From: [REDACTED]
To: [A303 Sparkford to Ilchester](#)
Cc: [REDACTED]
Subject: A303 Sparkford to Ilchester Dualling - Written representation
Date: 22 January 2019 21:35:35
Attachments: [Written representation to the ExA .pdf](#)
[Meeting Notes A303 31st May 2018.pdf](#)
[A local view of the detailed proposals February 2018.pdf](#)

A303 Sparkford to Ilchester Dualling – Project TR010036

Written Representation.

WORK NO.17 DOWNHEAD LANE

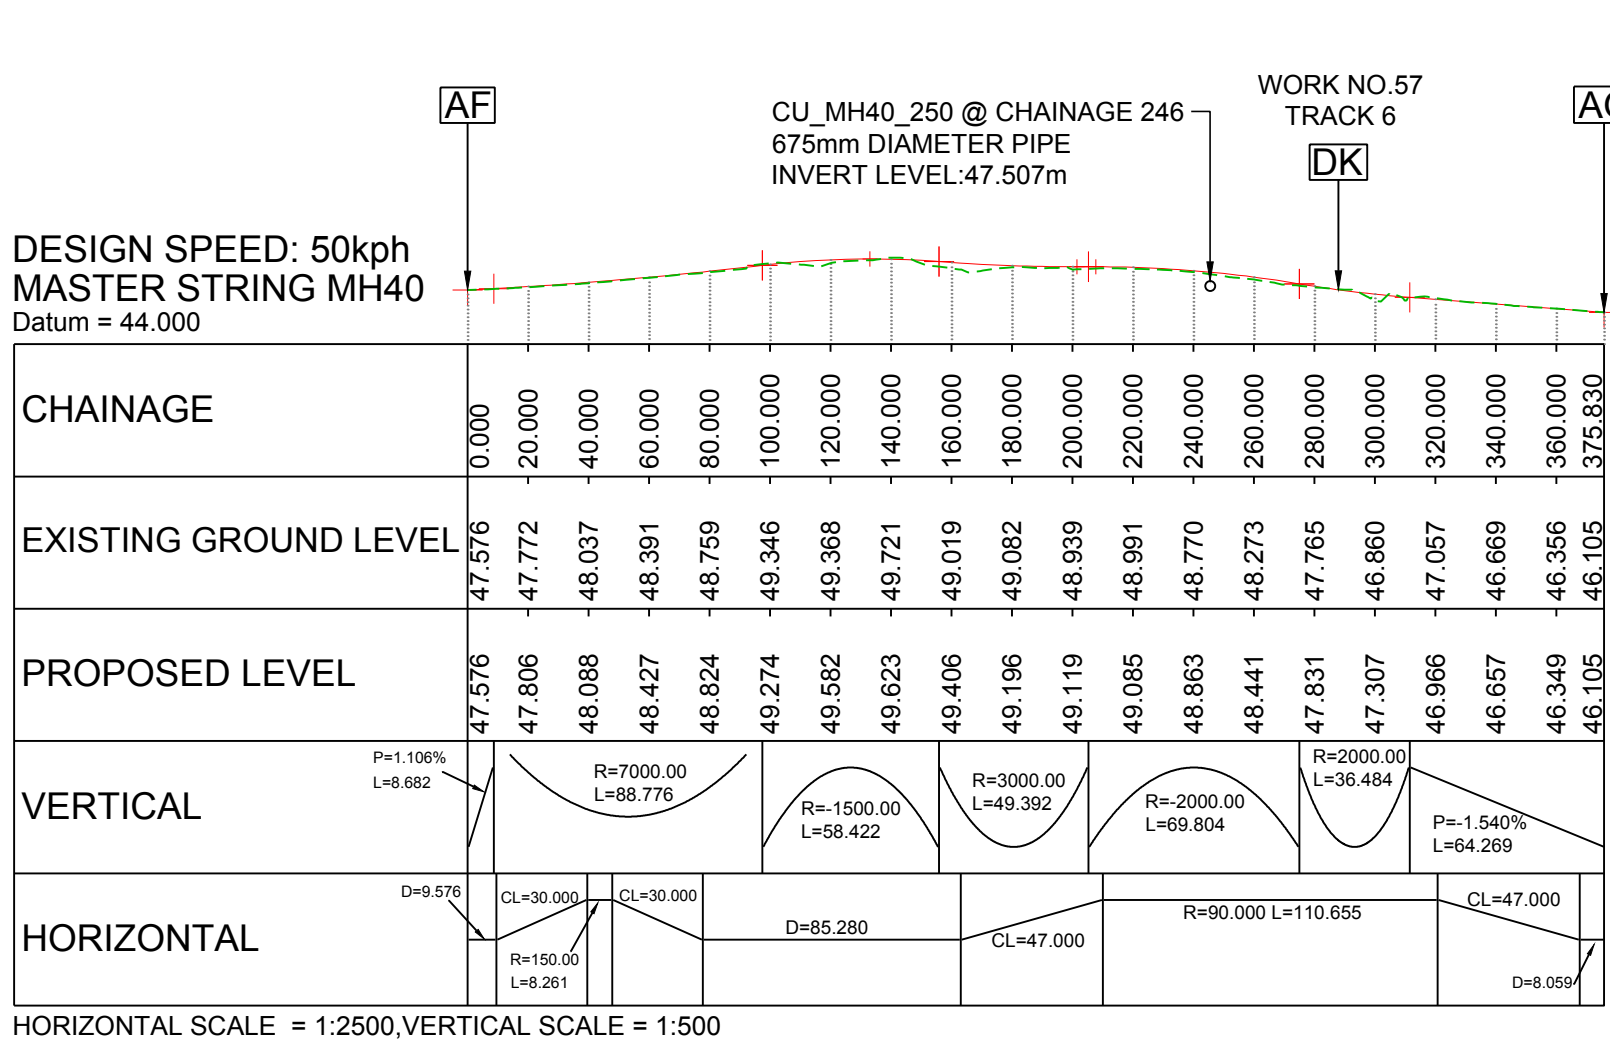
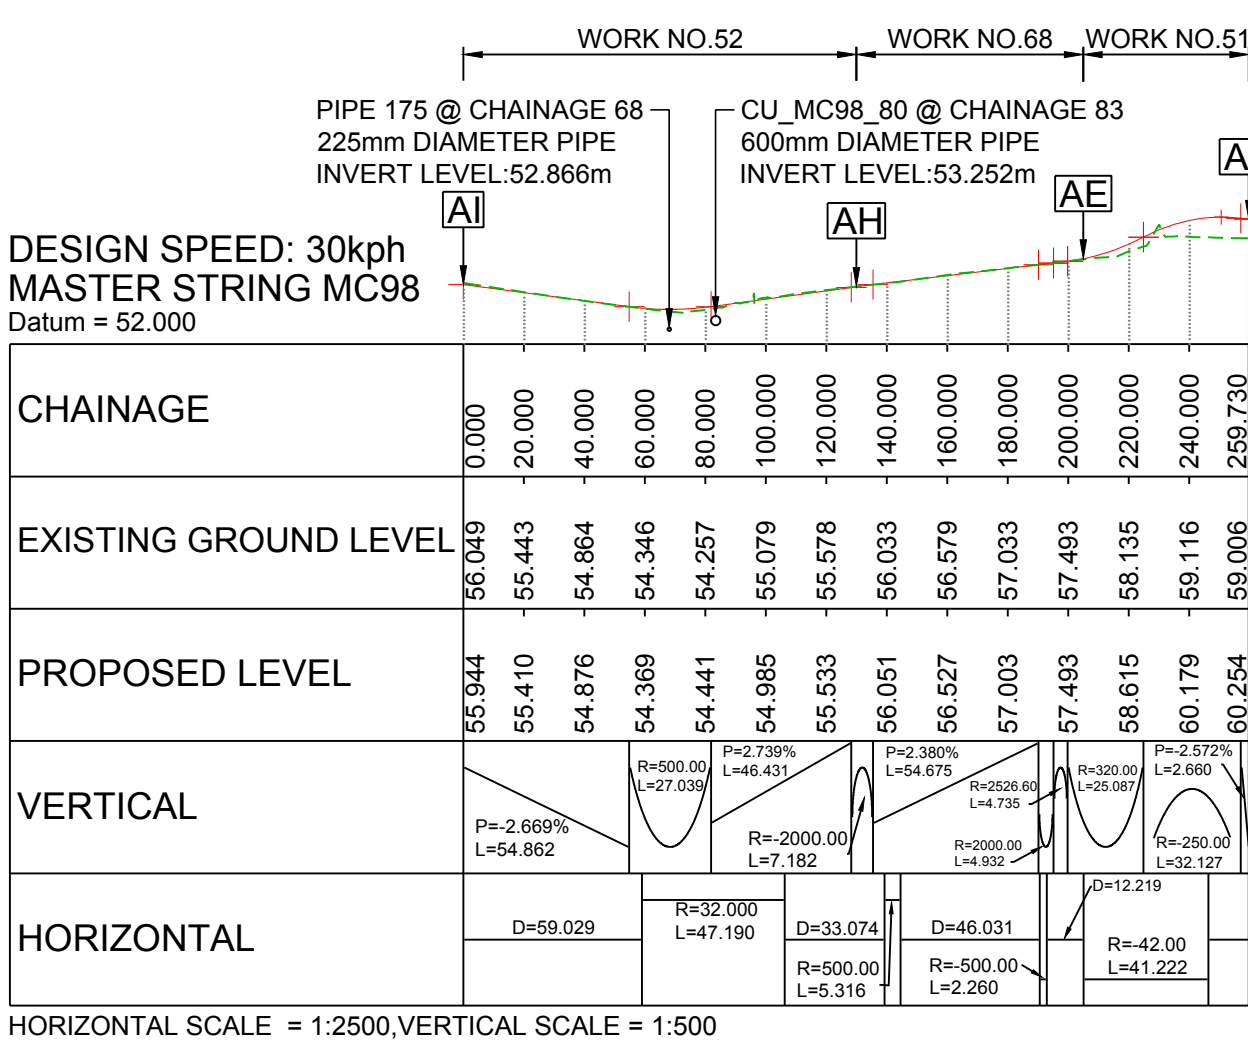
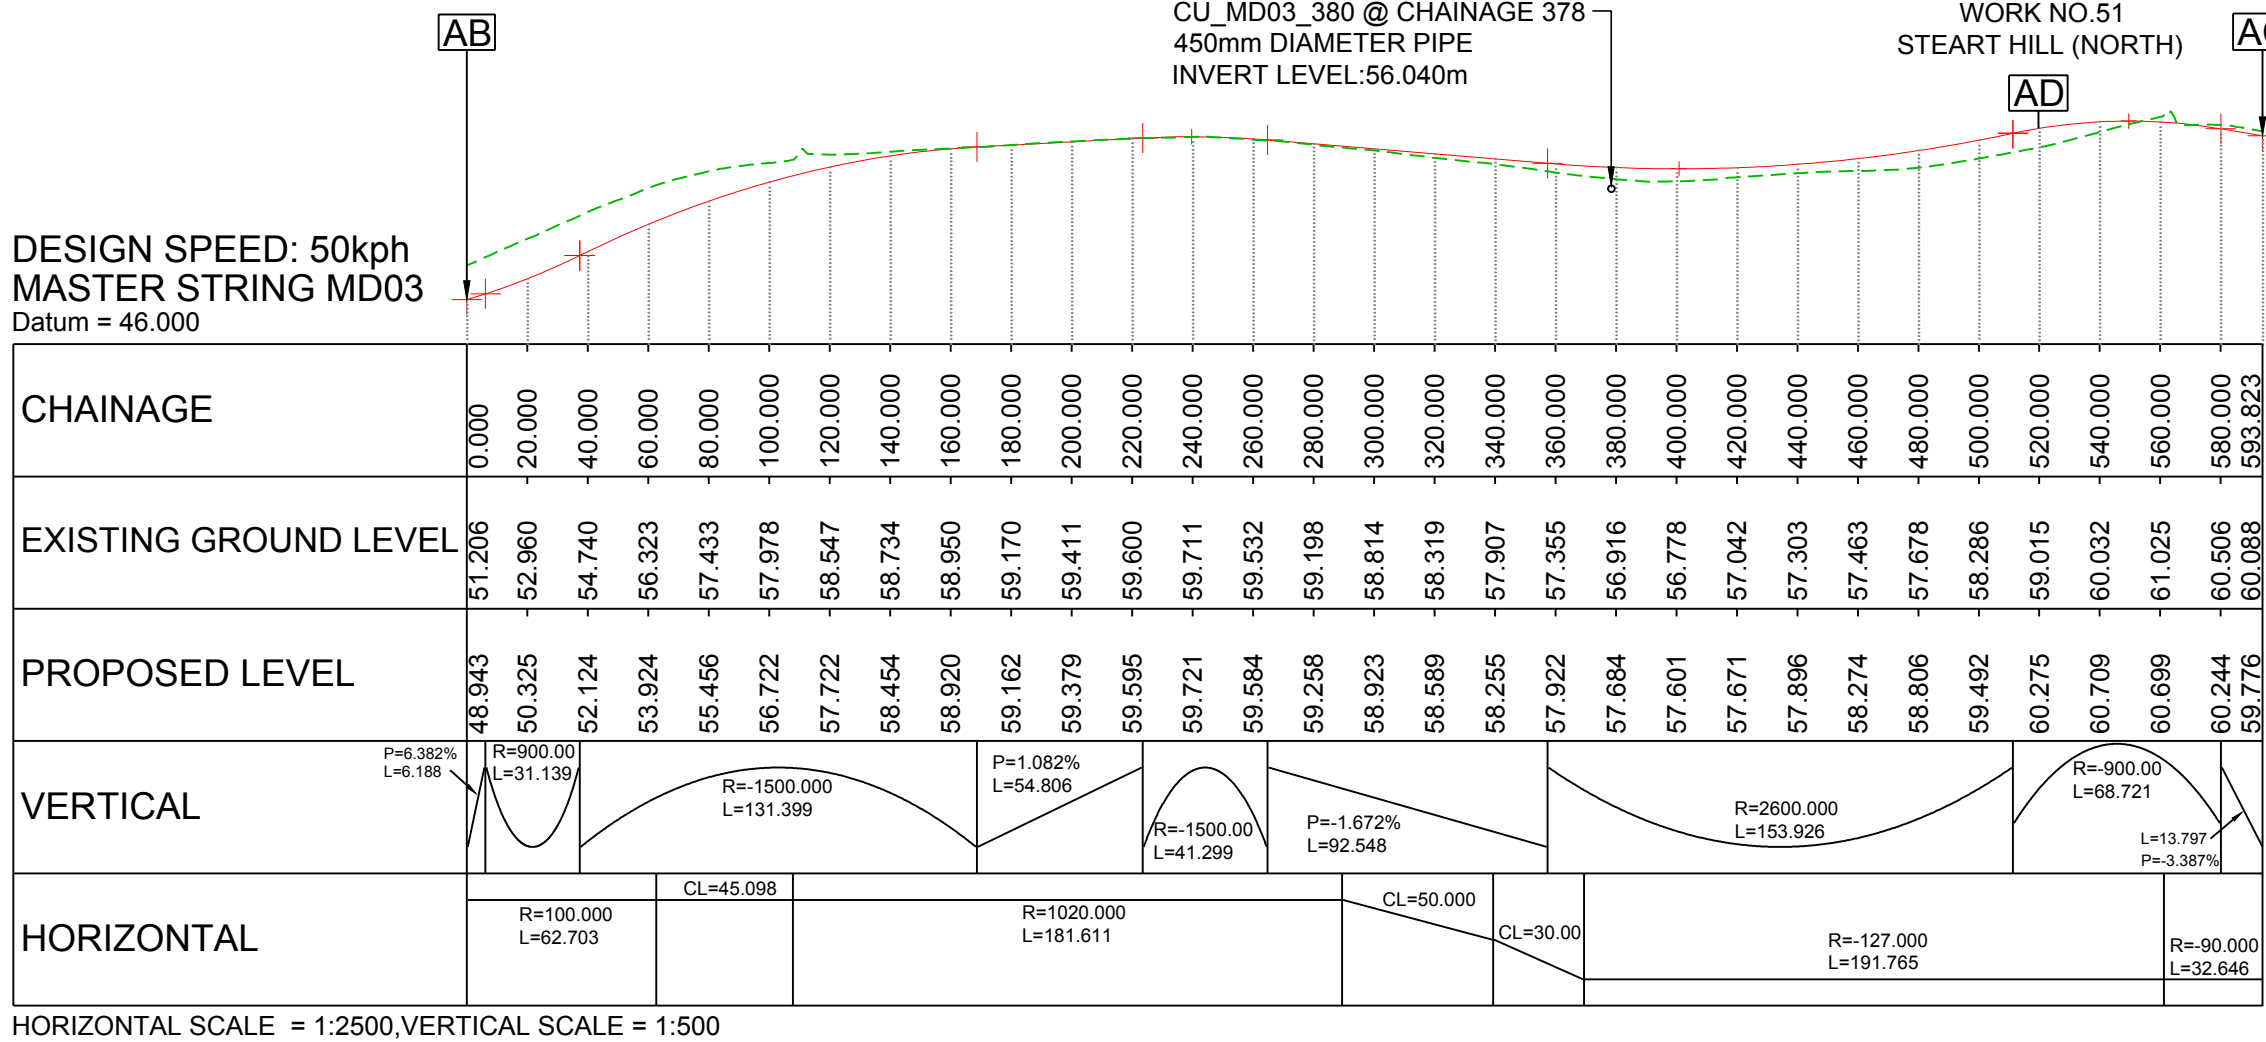
As a major safety issue and in Highways England's own words, from their Technical Appraisal Report (para 8. Safety Assessment), "Fewer junction means improved safety - reduces junction hopping and carriageway weaving". With less than 6kms between junctions at Podimore and Hazelgrove the safe use of the proposed dual-carriageway could be improved by removing the mid-section east-bound junction at Downhead.

I believe to provide this proposed east-bound junction is questionable and certainly not a good use of public money to provide a junction just for local users which in the future becomes inaccessible by two large local agricultural businesses.

WORK NO.26 WORKS TO FORMER A303
WEST OF HOWELL HILL

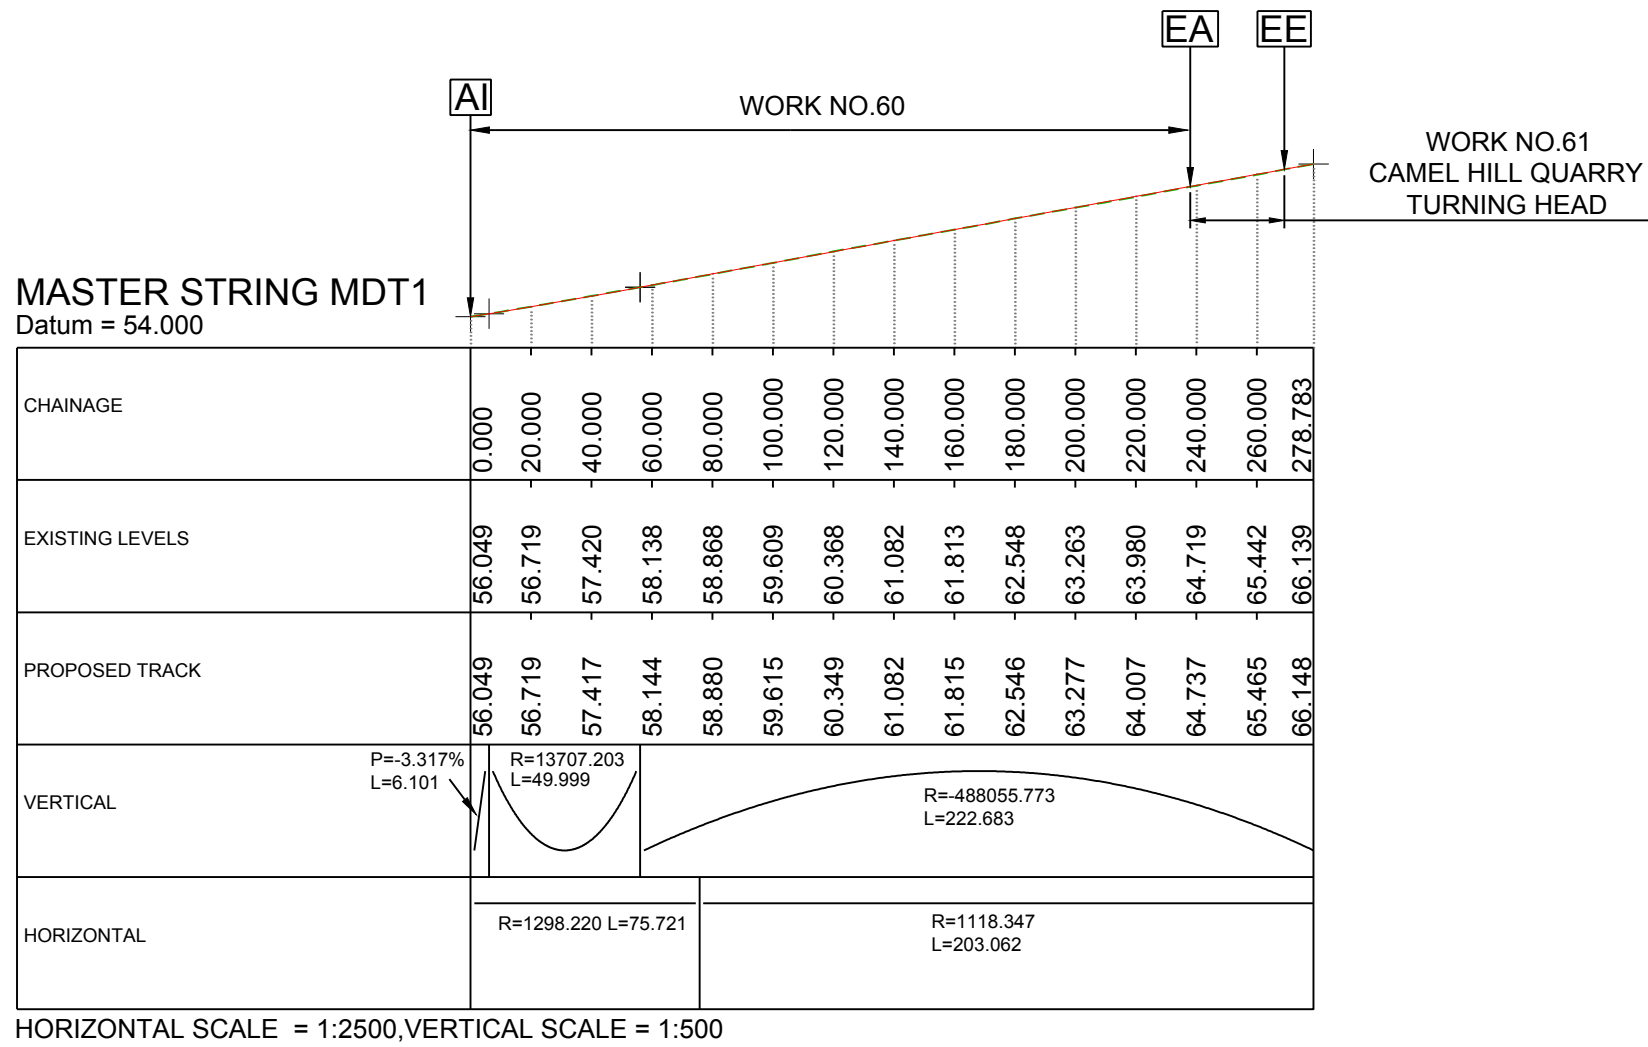
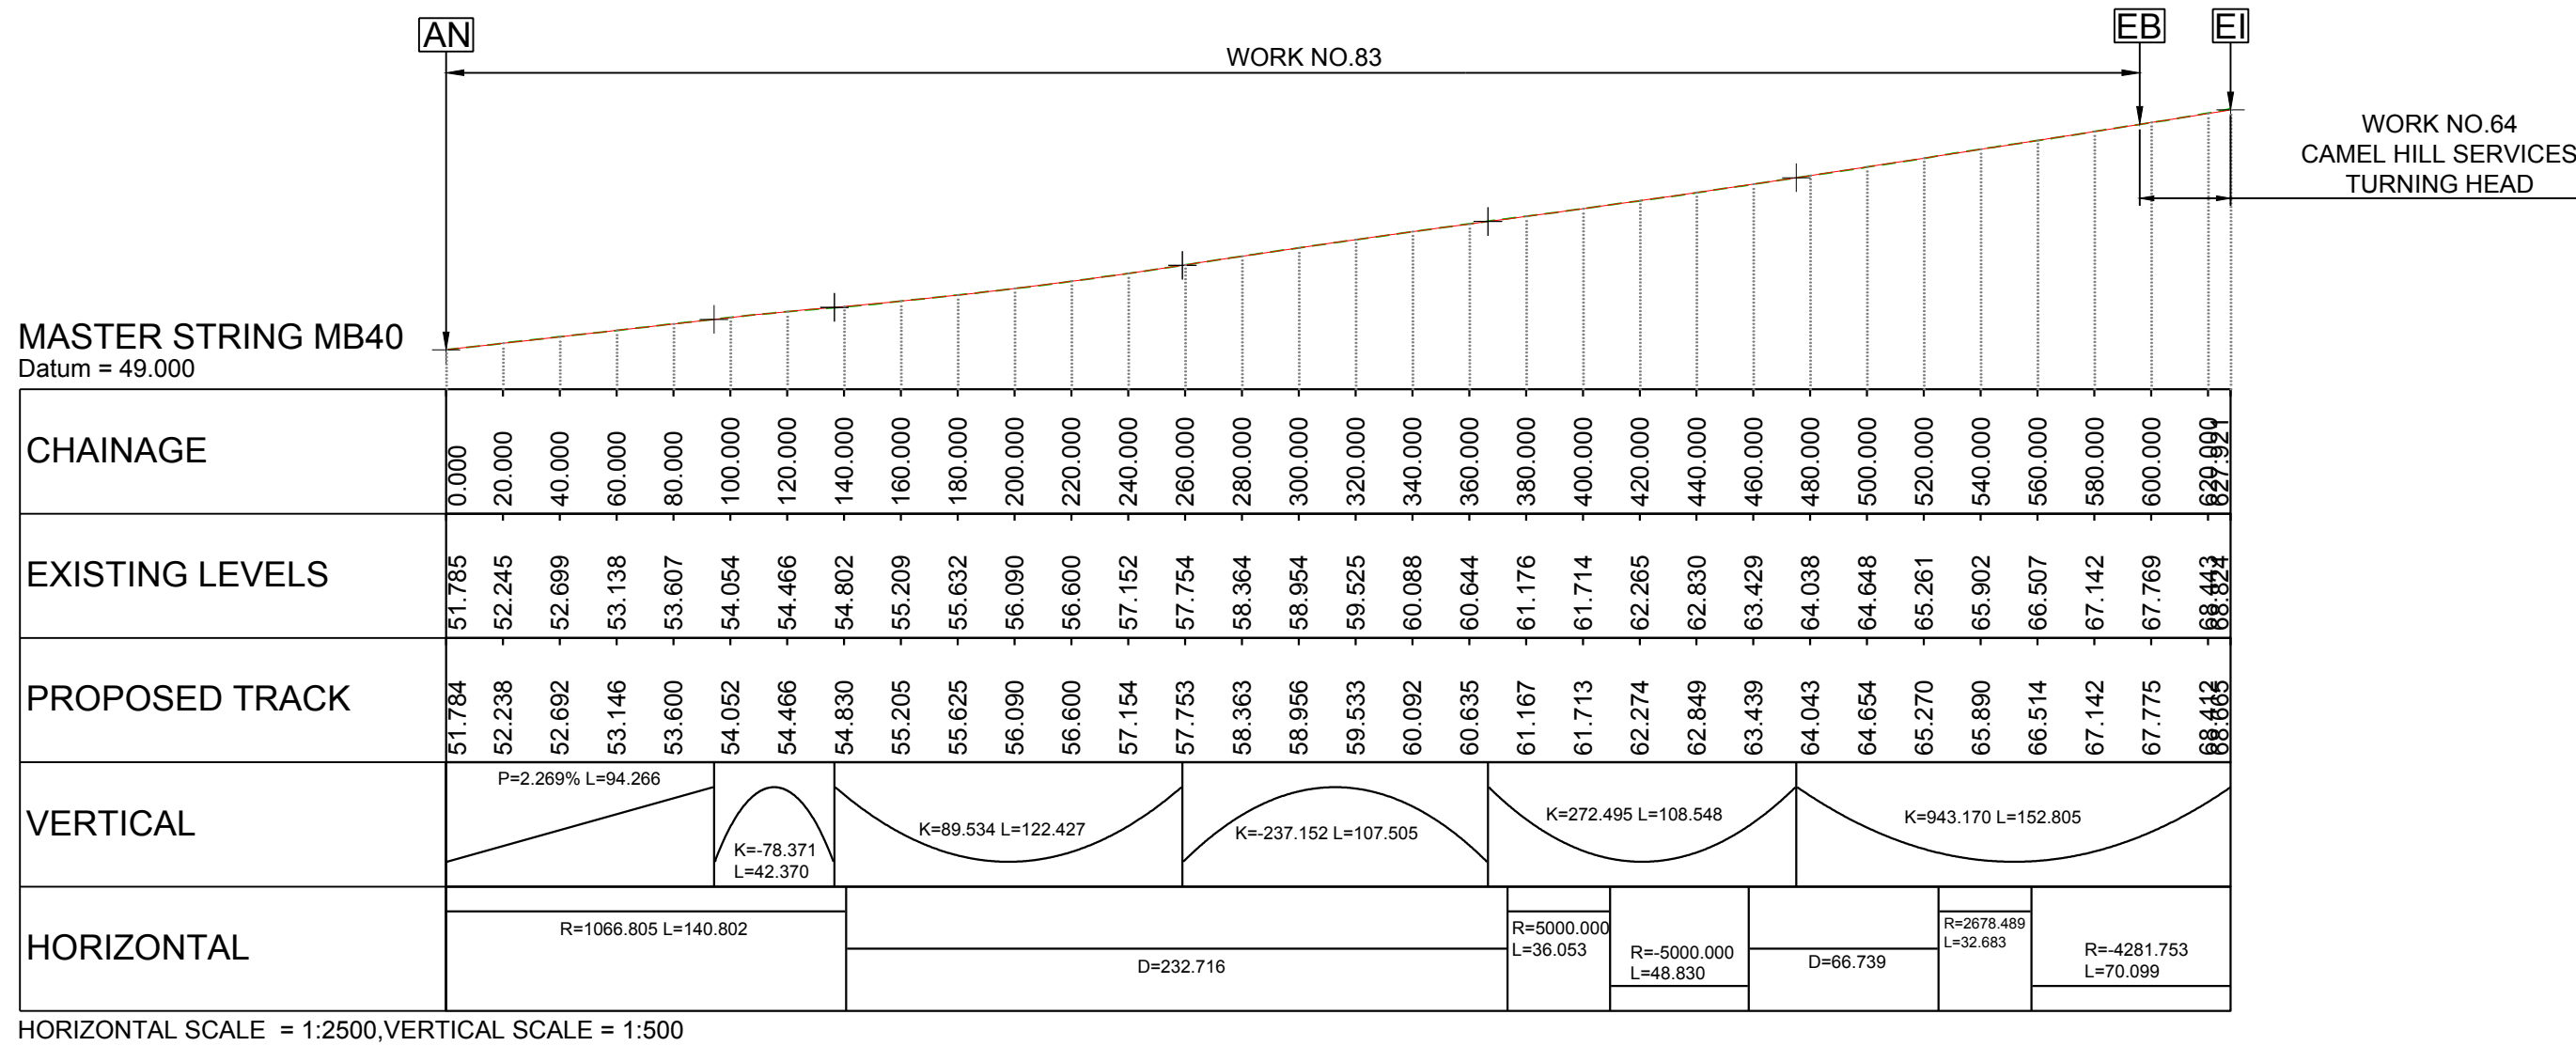
I understand that to join the terminated end of the existing A303 at Camel Hill to the proposed field access road east of Howell Hill and to the south of the new dual carriageway would require, approximately, an additional 370 metres of tarmac road.
